Our Reference: NS212832
DPHI's Reference: SSD-96248991:

Re: Rouse Hill Hospital – HI24498

In relation to the Hills Shire Council's comments on the Civil Design for SSDA Design for the new Rouse Hill Hospital d Corner of Commercial Road and Windsor Road, Rouse Hill) as shown in the below table:

SSDA
BULK EARTHWORKS SECTIONS
SHEET 1

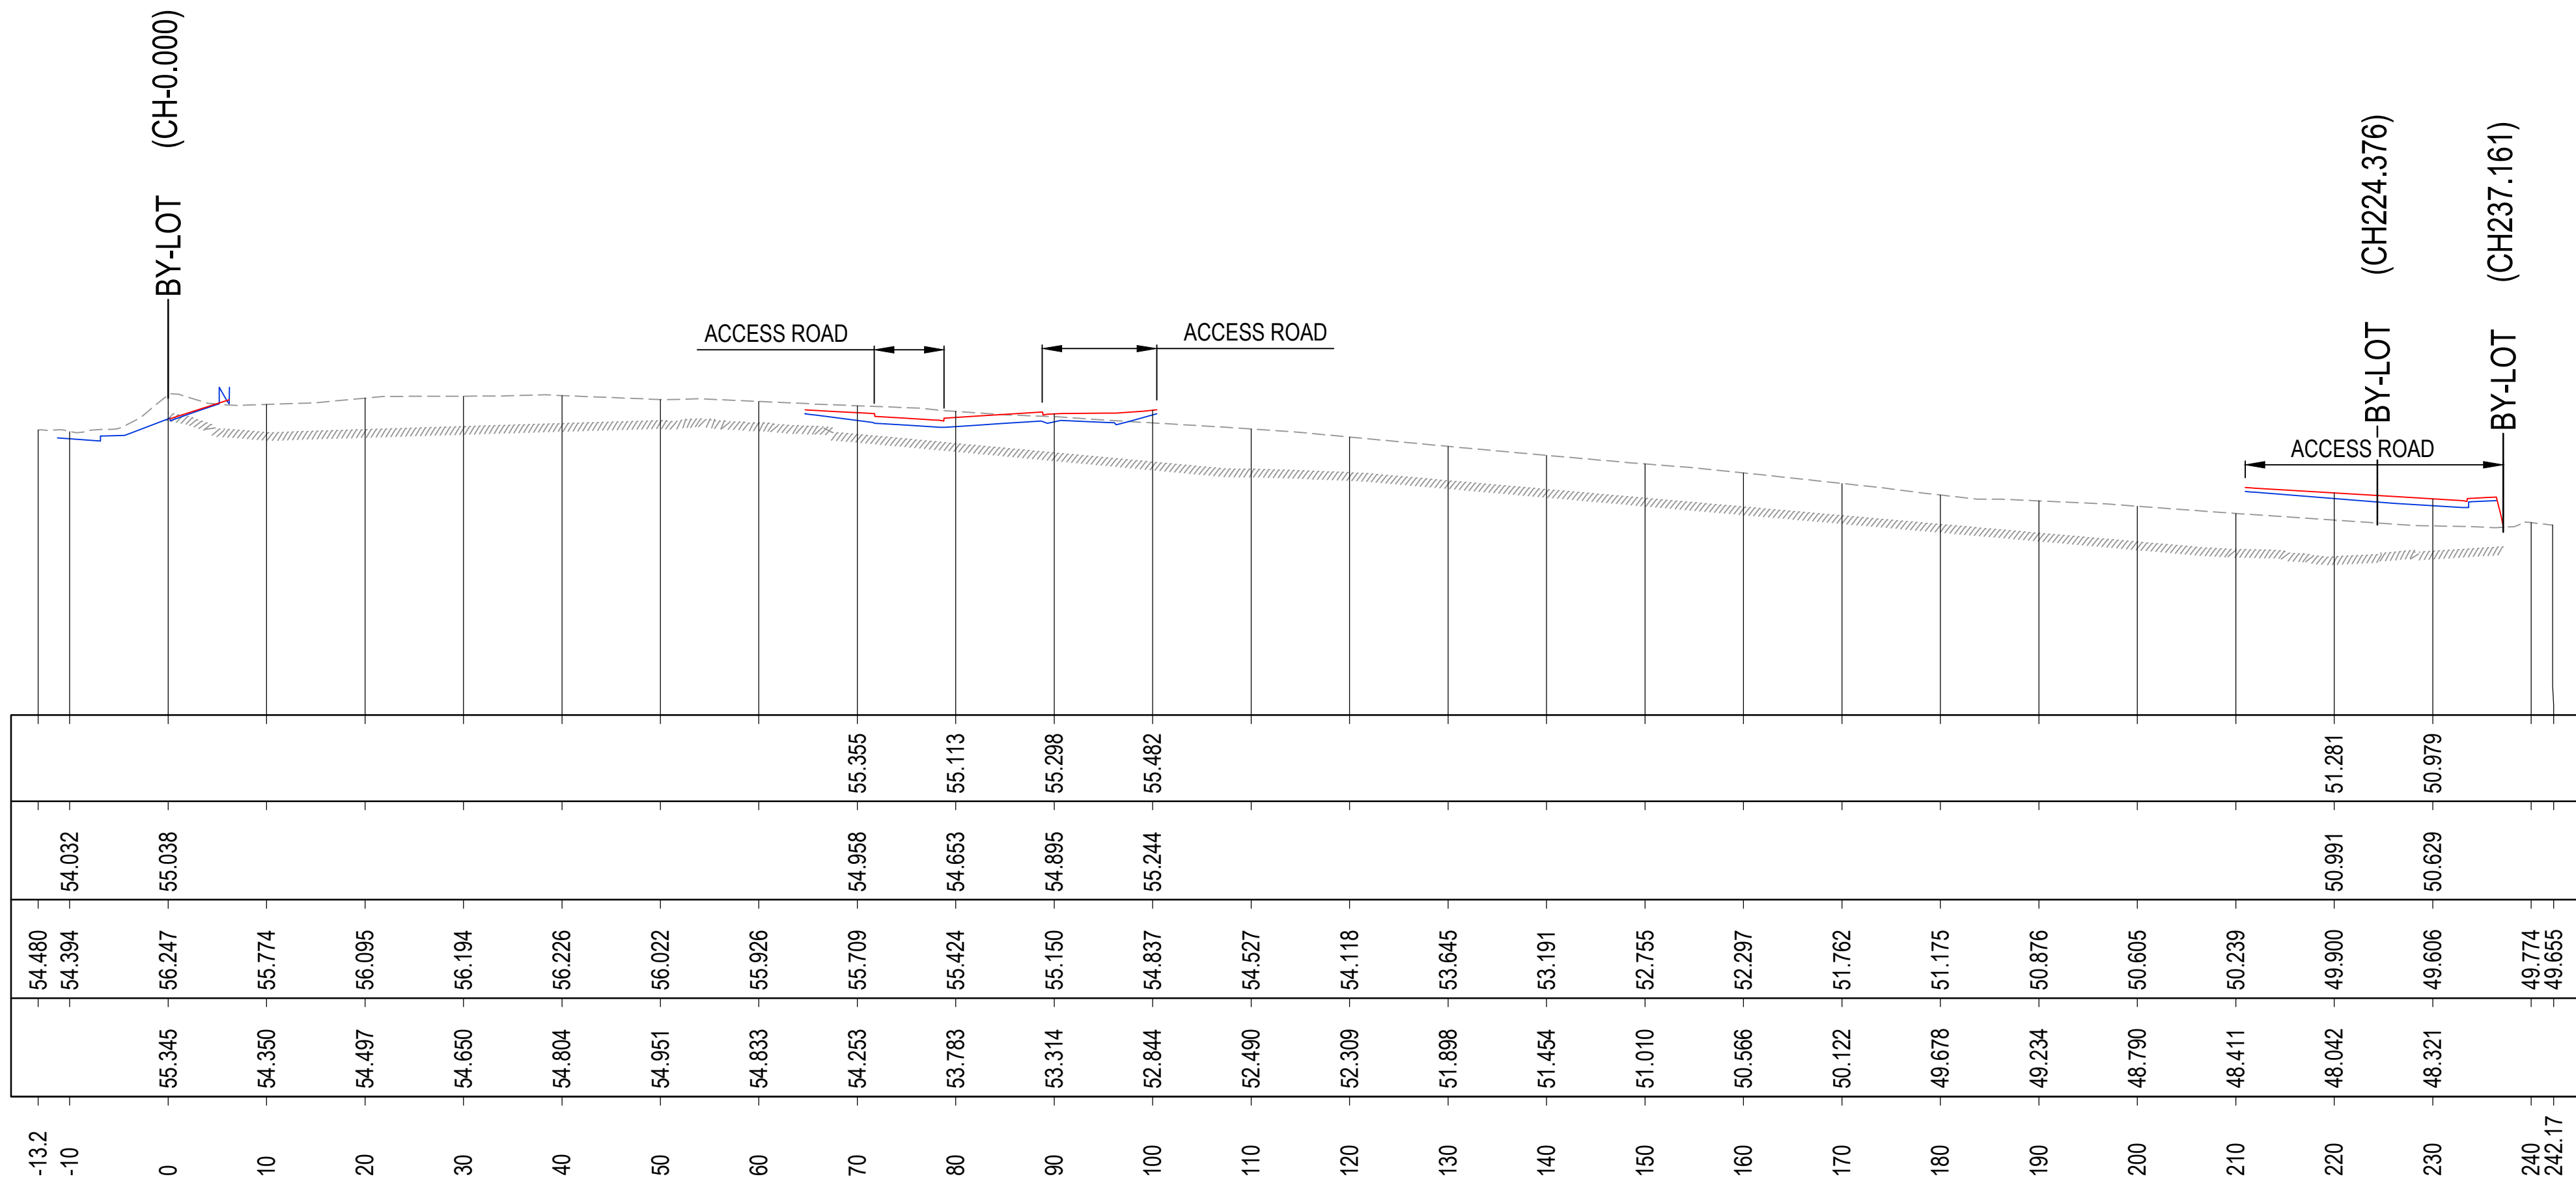
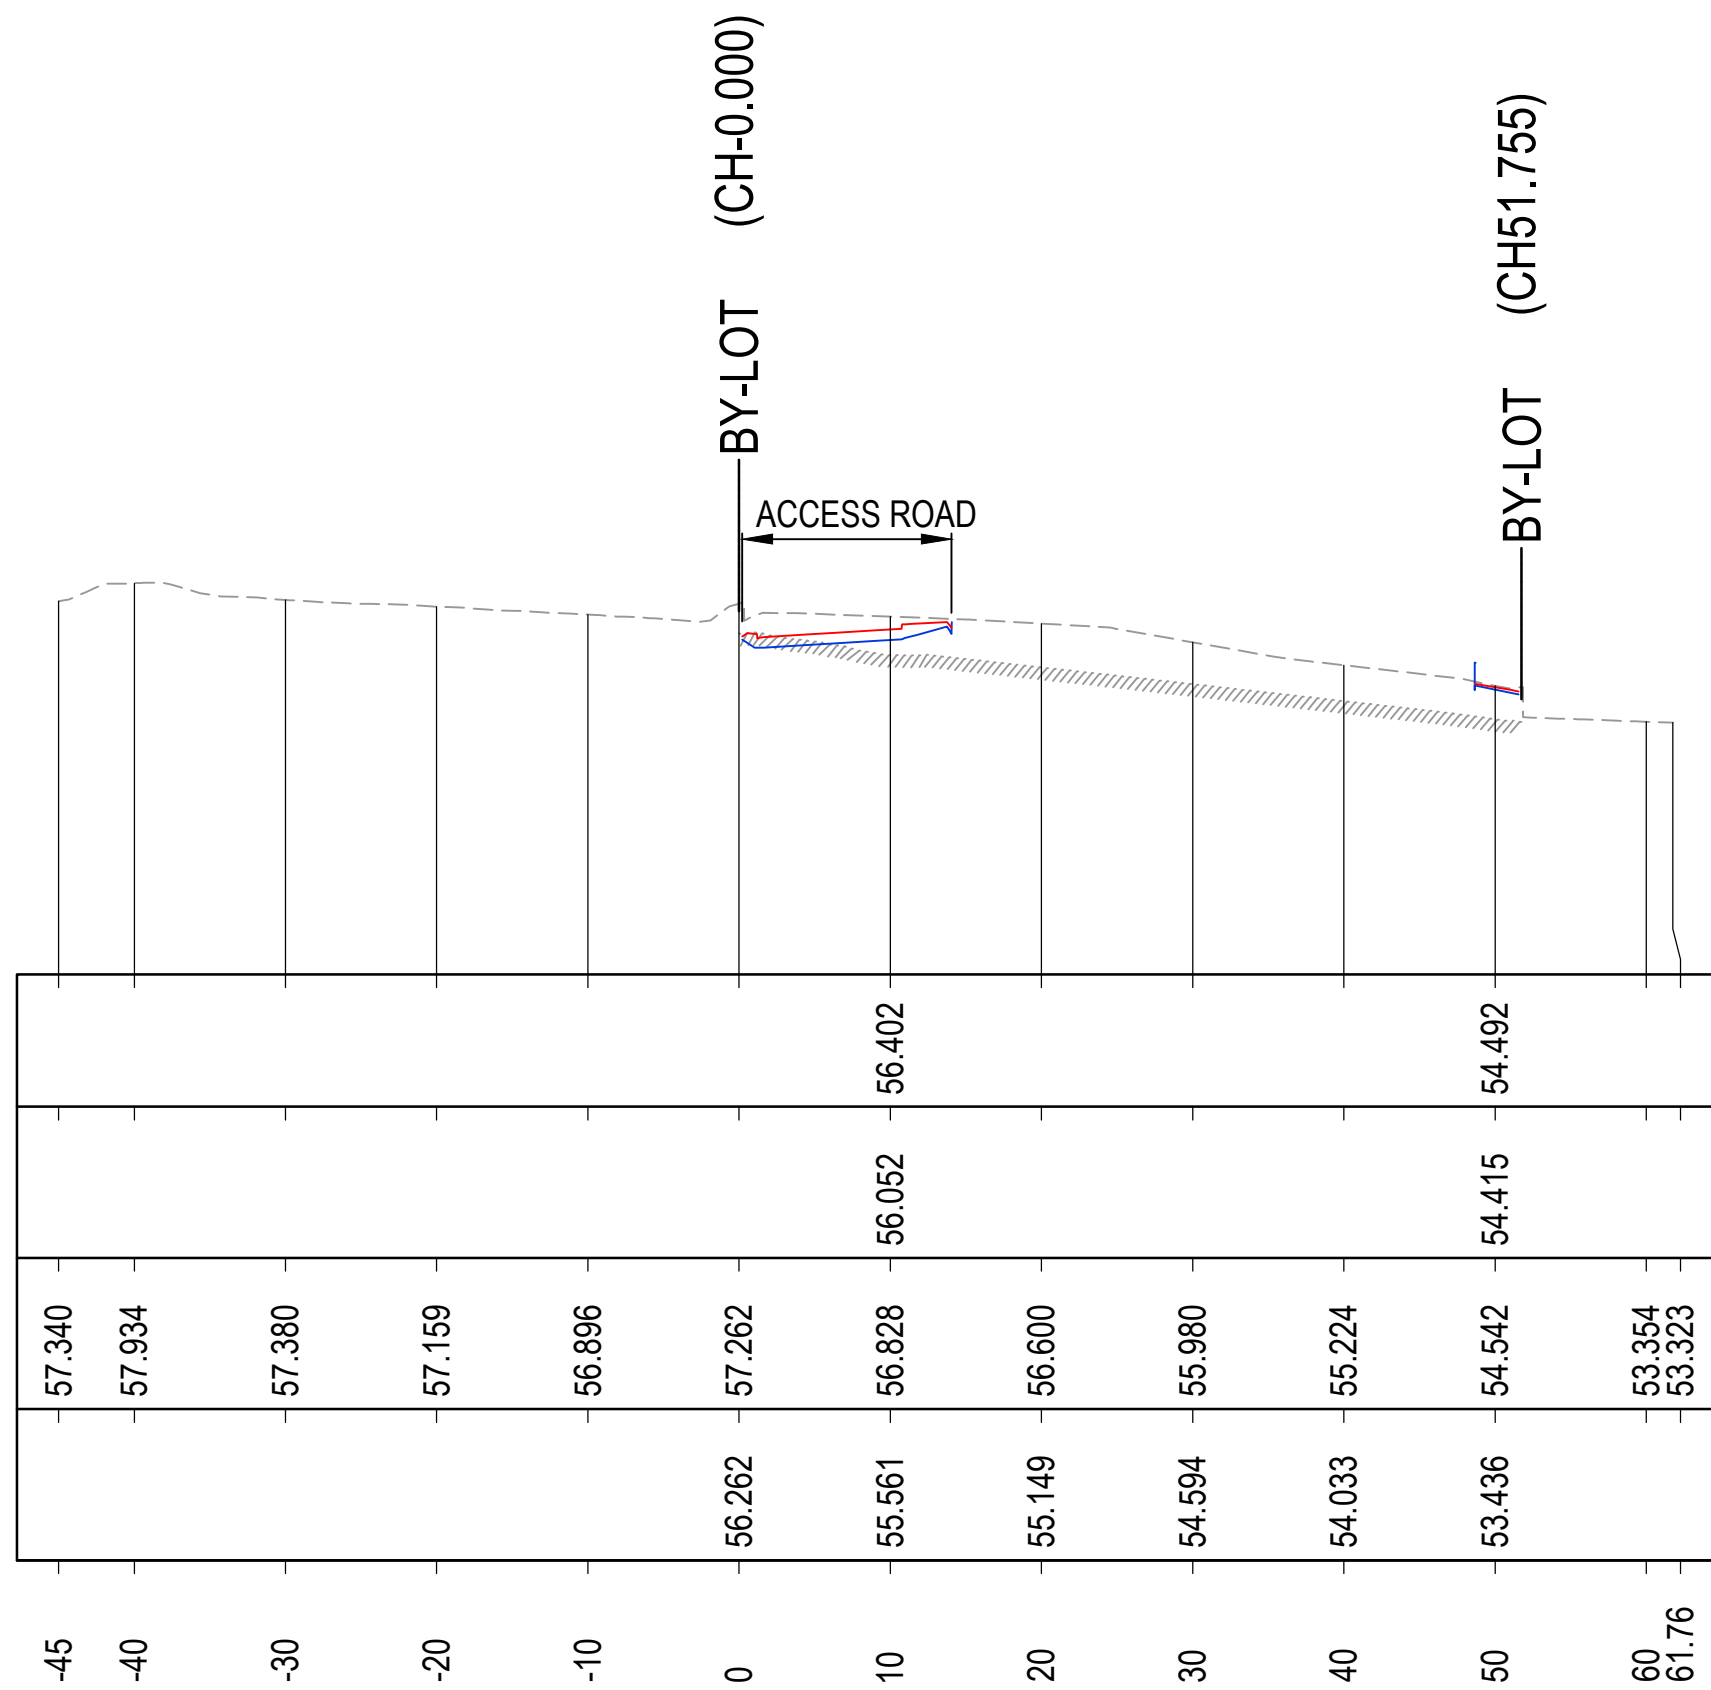
Submission	Themes	ACOR Response
<p>kerbs, gutters, footpaths, final road build up and surface are not included in early works and are shown only for information” the future surface levels can only be vary by 100mm or less is required to be clarified. The surface level will be fixed by this Development Application approval hence the earthwork plan, cut and fill, and retaining wall (including ToW, BoW, long section) shall be provided on a separate plan any batter shall be 1:4.</p>		<p>However, the civil constructions work is split into two different packages Early Works and Main works design packages. Each package will capture different civil elements as the following:</p> <ol style="list-style-type: none"> 1- Early Works design package: this will capture mainly the temporary construction access roads and main works stormwater drainage network including underground on-site detention basin (OSD). Installation of this OSD has been approved under a Part 5 (REF) approval. 2- Main Works design package: this will capture main roads pavement including the kerb, gutter, landscape and footpath. The approval path for Main works State Significant Development Application (SSDA) <p>During the design of Early Works access roads intentionally the finish level adopted to allow minimum earthworks to construct the main works roads by reducing the levels to allow the pavement layers for the main works road.</p> <p>The design has adopted Hill Shire Council and the geotechnical recommendation which allow up to 1V:2H batter slope (refer to Design Guidelines Subdivision/Developments, Table 3.9)</p>
